TECHNICAL MEMORANDUM

DATE	20 December 2022	REF	NSWDPE239607
TO	Ms Rose-Anne Hawkeswood – NSW Department of Planning and Environment	REV	Rev1: Final
FROM	Sophie Pape, Earth Systems Jeff Taylor, Earth Systems	PROJECT	Bowdens Silver Mine

UPDATE ON INDEPENDENT REVIEW – WATER BALANCE MODELLING AND SURFACE WATER MANAGEMENT

Figure 23 – Southern barrier maximum development (Year 12).

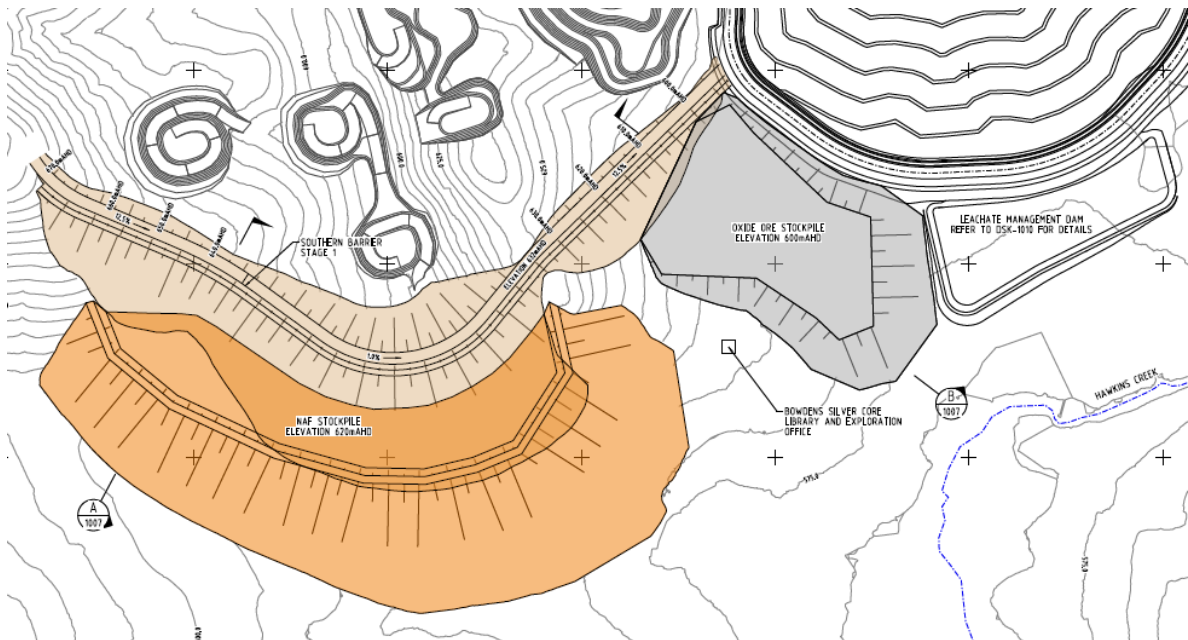
- ▶ It is understood that Blackmans Gully would flow beneath the Southern Barrier (a “NAF” waste rock dump) and discharge off site, but there appears to remain a risk of drainage/seepage from the barrier entering Blackmans Gully. The Southern Barrier design should include provision for containment of all drainage (runoff or seepage) from the barrier and/or a contingency plan should be developed for Blackmans Gully.
